**From:** Amanda Scholes on behalf of Planning.Responses  
**Sent:** 01 December 2021 09:50  
**To:** Planning Scanning  
**Subject:** FW: Planning Re-Consultation on: Y/156/21/DOC

**Application No:** Y/156/21/DOC  
**Registered:** 3rd November 2021  
**Site Address:** Land East of Drove Lane Yapton BN18 0EB

**Description of Works:** Approval of details reserved by condition imposed under Y/92/17/OUT relating to conditions 4-phasing for construction of dwellings & associated highways & public areas, 9-surface water drainage, 16-Construction Management Plan, 21-Travel Plan, 22-energy conversation, on site energy renewable devices & 25-electric vehicle charging strategy.

I am able to inform you that I have received an amendment to the above application dated 23rd November 2021 relating to: Amended Drainage Plans (at Applicant request)

CIVIL / STRUCTURAL DESIGN RISK MANAGEMENT

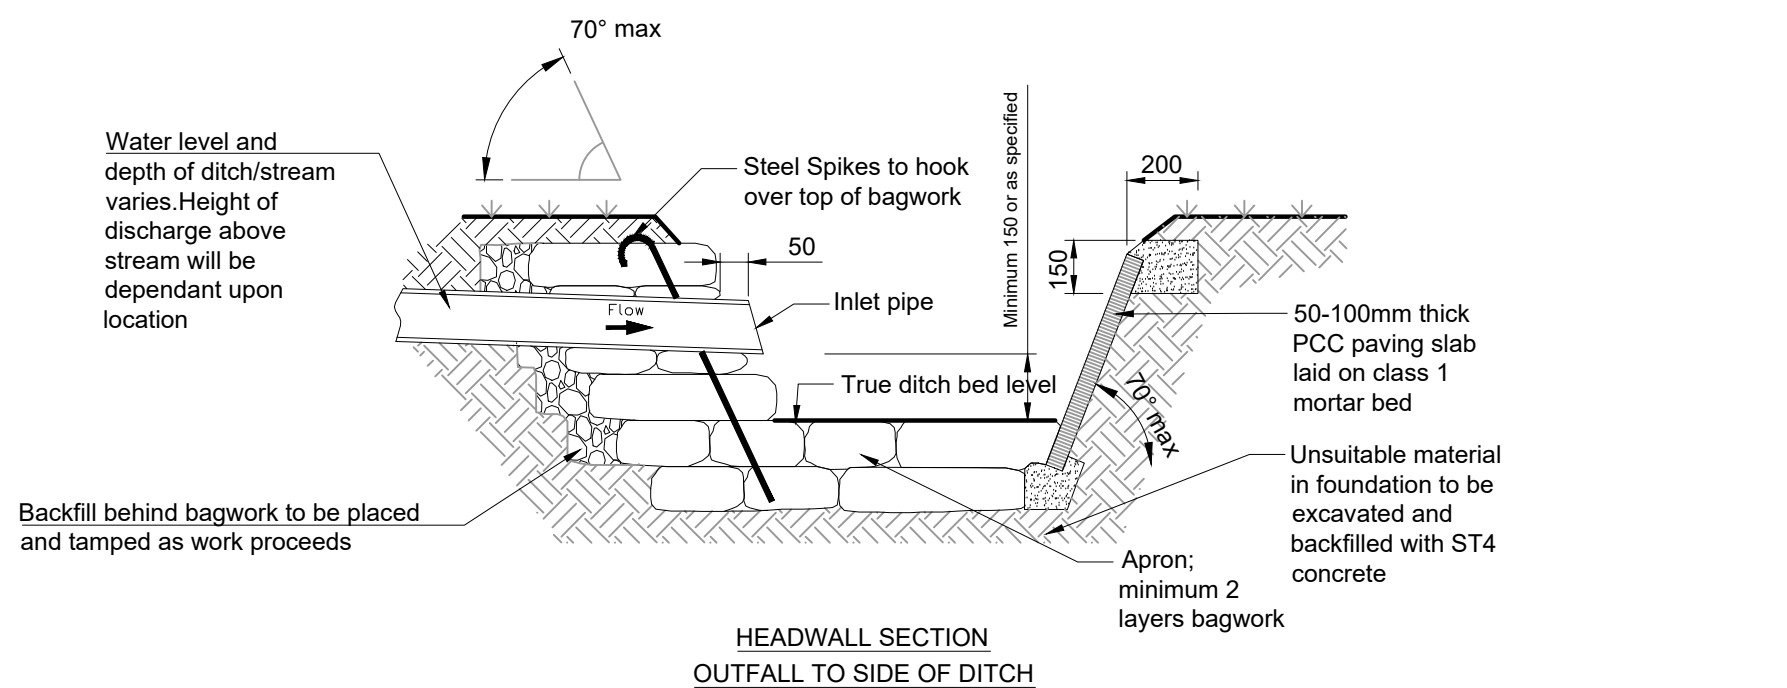
1. Suds detail sheet appears to detail and list features which are to be lined with an impermeable liner, contrary to the statement provided. Please confirm whether all features below peak groundwater level are to be impermeably lined.

8. Flotation calculations need to be supplied to support design of features which are below groundwater level and require lining.

14. Catchpits must be provided upstream of connections into permeable paving sub-base.
15. Pond 5 appears to be bunded. Please provide further details, i.e. crest width and slope on landward side. Pond 6 and 7 also appear to be bunded, same request applies.

Drawn	Date	Checked	Date	Approved	Date
SM	07.2020				
Scale	NTS	Orig Size	A1	Dimensions	Metres
Project No.	133647	Drawing File	PLN_1_4101 Typical SUDs details.dwg		
Drawing No.	PLN_1_4101			Rev.	G

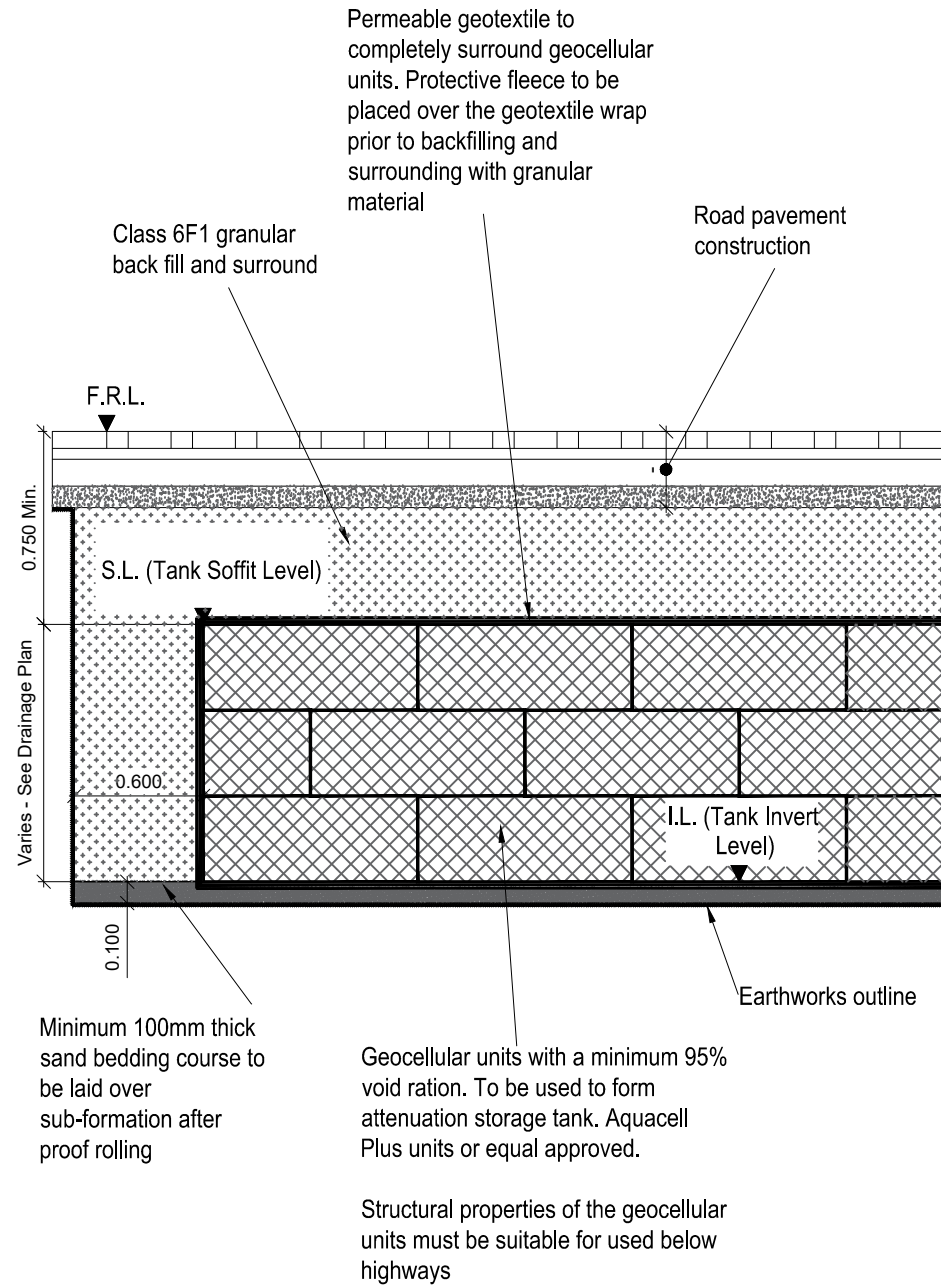
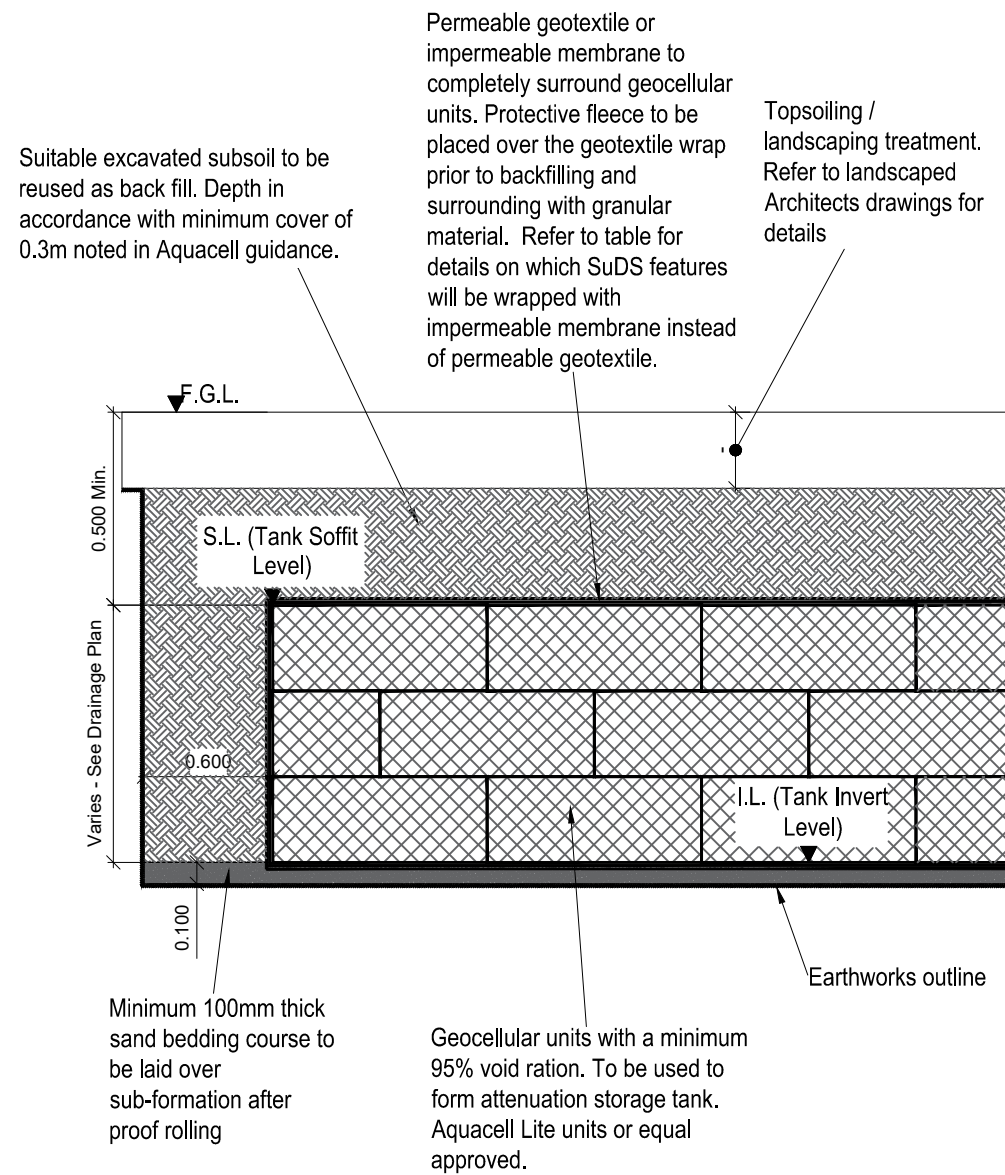
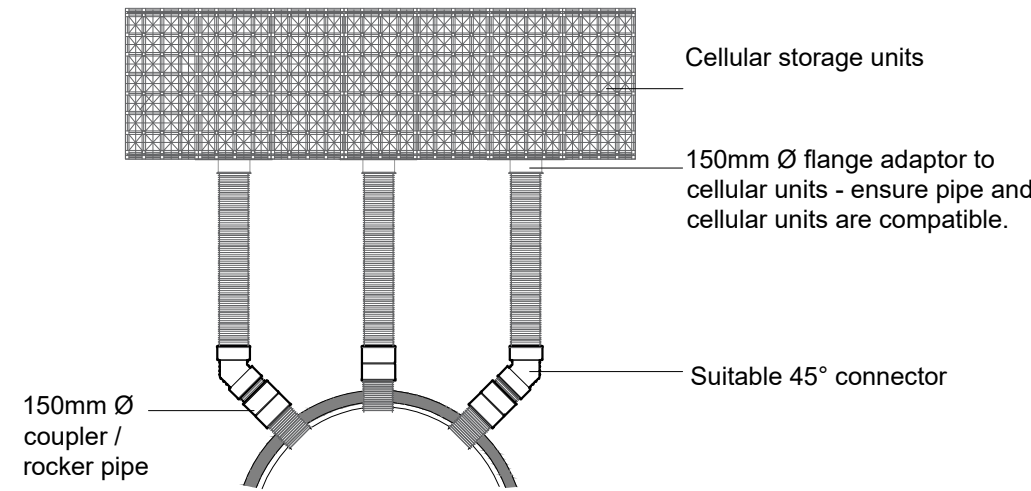
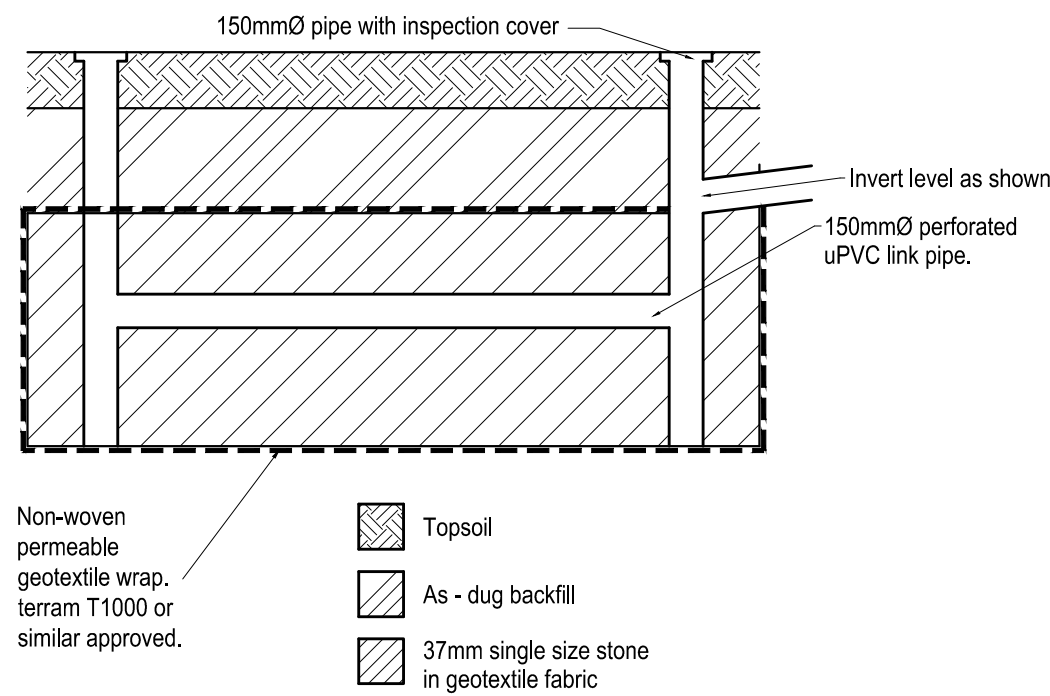
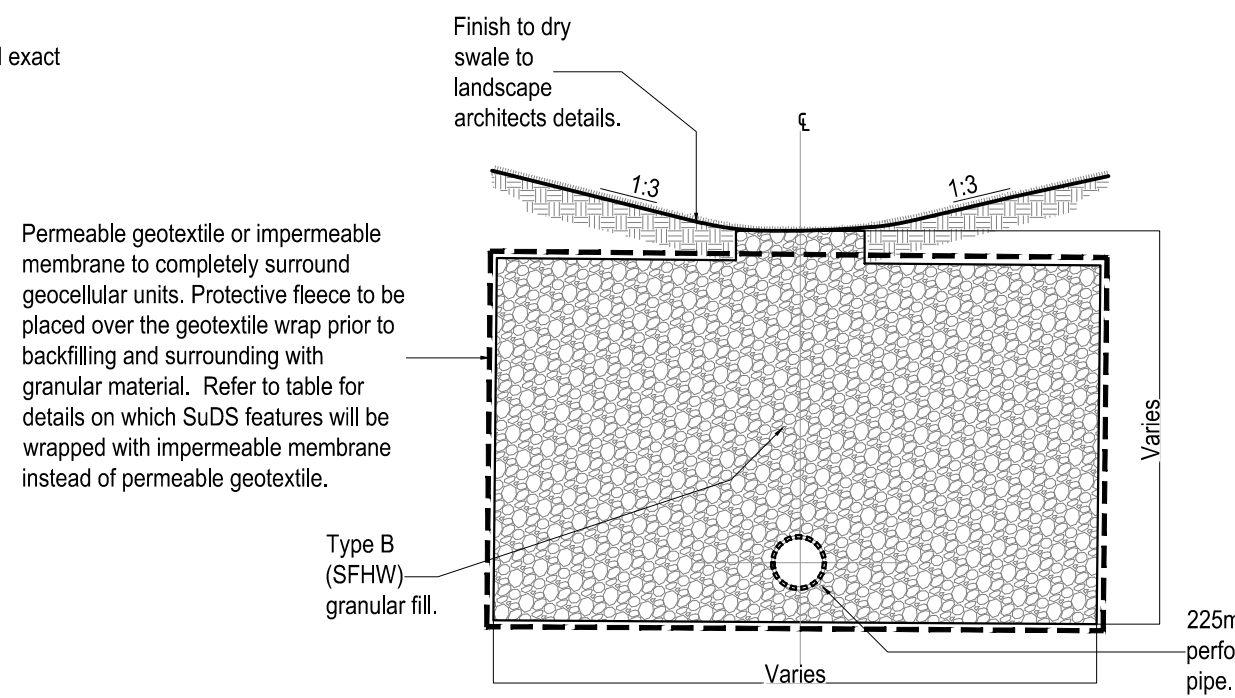
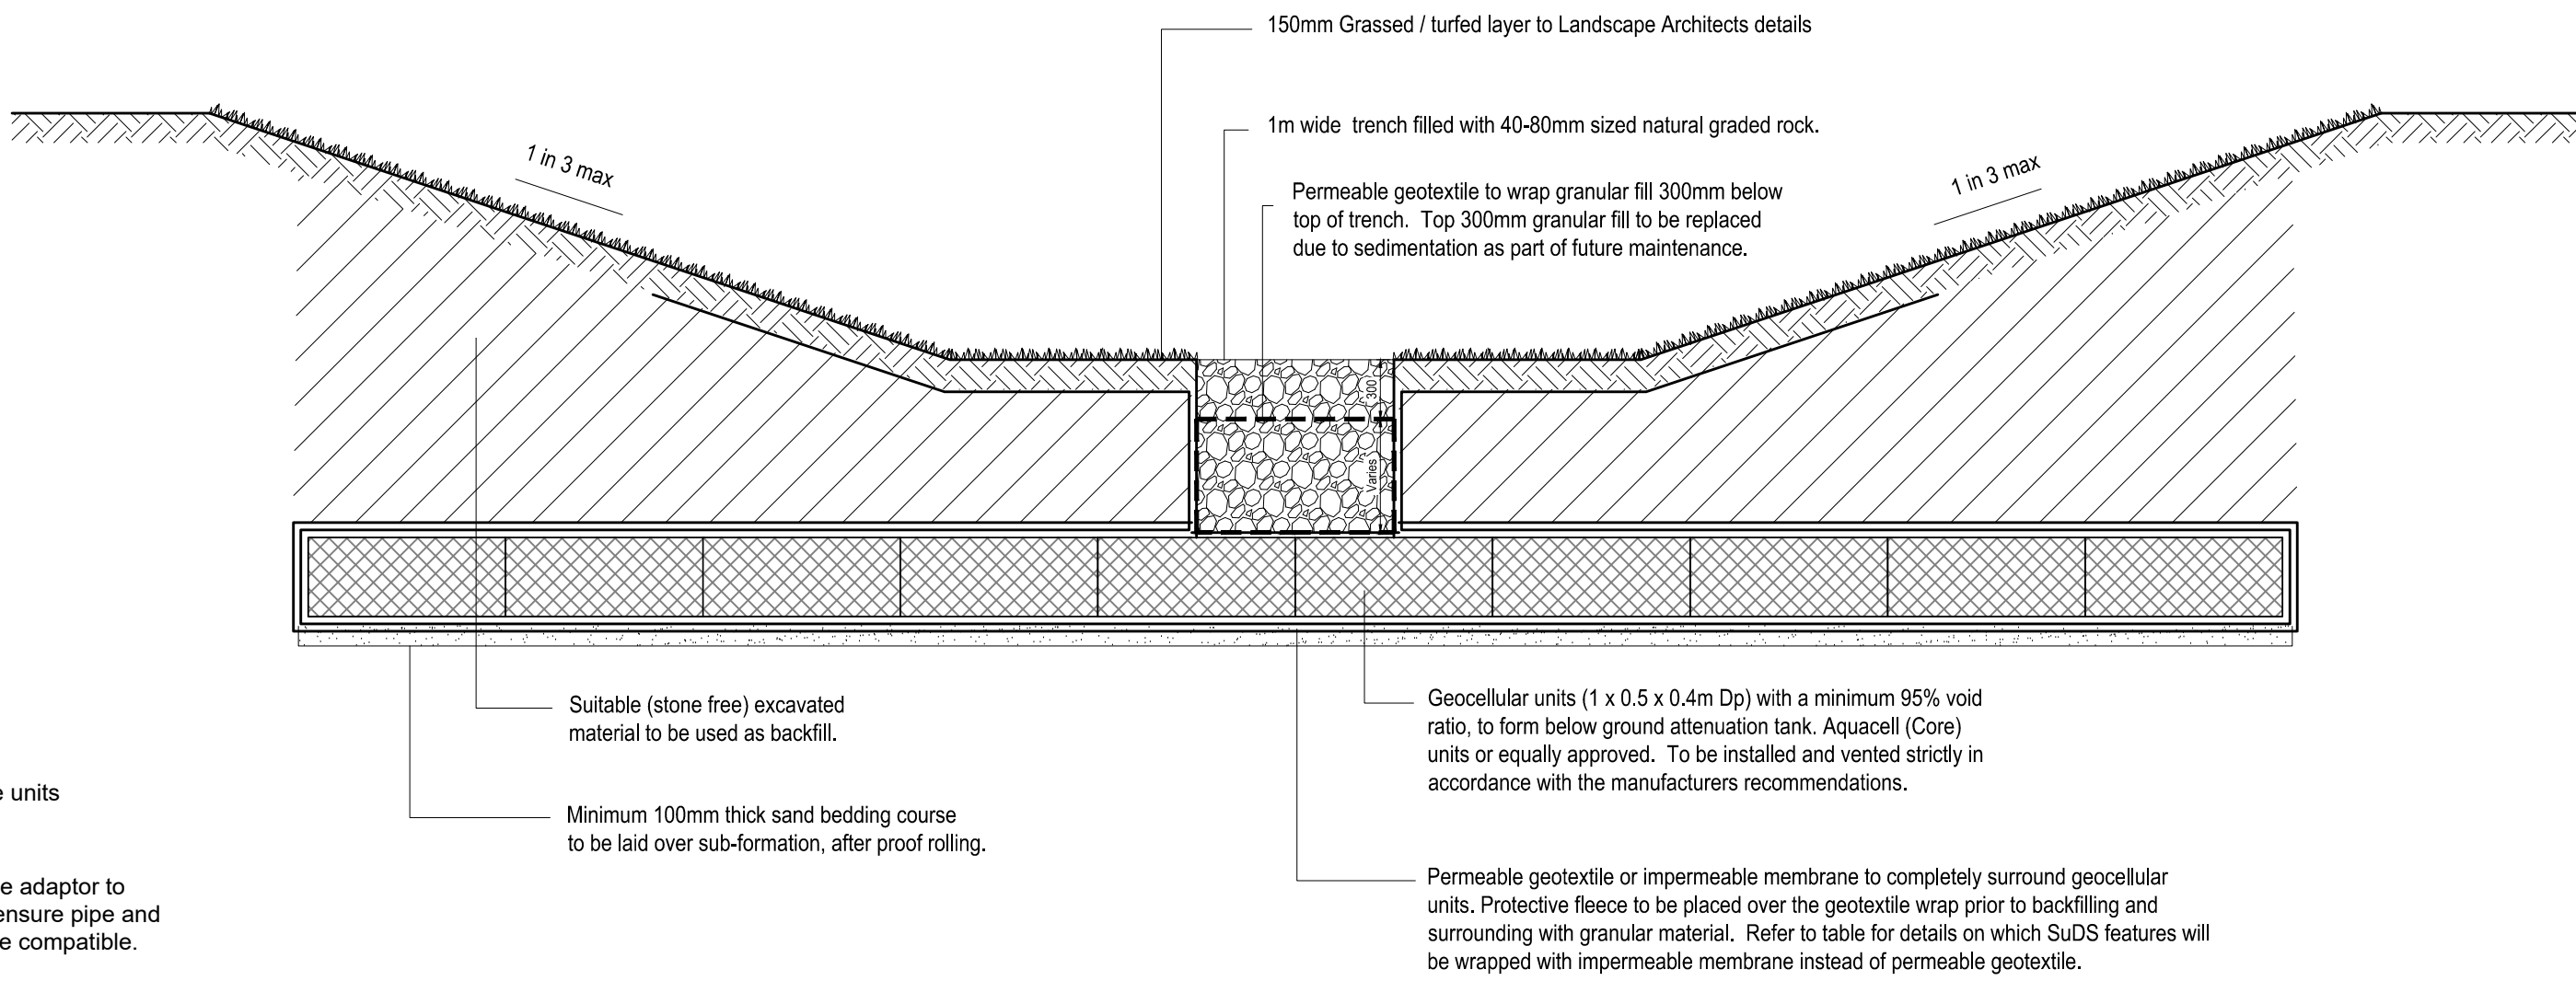
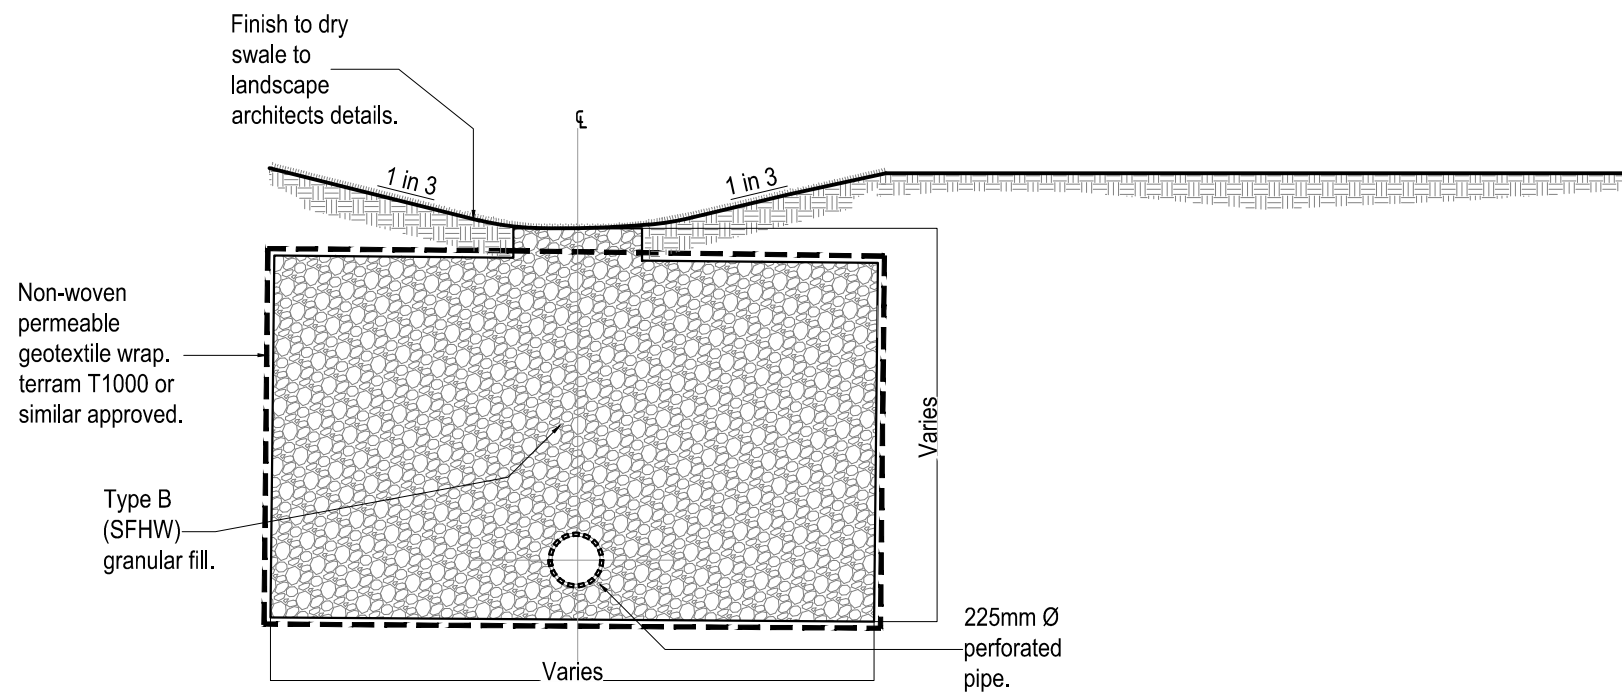
6. Hydrobrake construction detail drawing needs to show cable for operating bypass door and where this will be fixed.
7. Specific geotextiles should be included on construction details of attenuation tanks, rather than just stating "permeable geotextile" a specific type should be specified.

11. All permeable paving areas should be reviewed to ensure any which have formation levels below peak groundwater level are lined.
12. Calculations include 450mm depth of sub-base, yet construction detail states minimum 400mm. Please update construction detail drawing.

13. Any permeable paving sub-bases which have rwp's discharging into them should be impermeably lined, or should ensure that point of discharge of rwp is a minimum of 5m from buildings.

4. There are inconsistencies between permeable paving sub-base formation level shown on plan and those in calculations.
5. Swale 3 has inconsistent dimensions between plan and calculations.
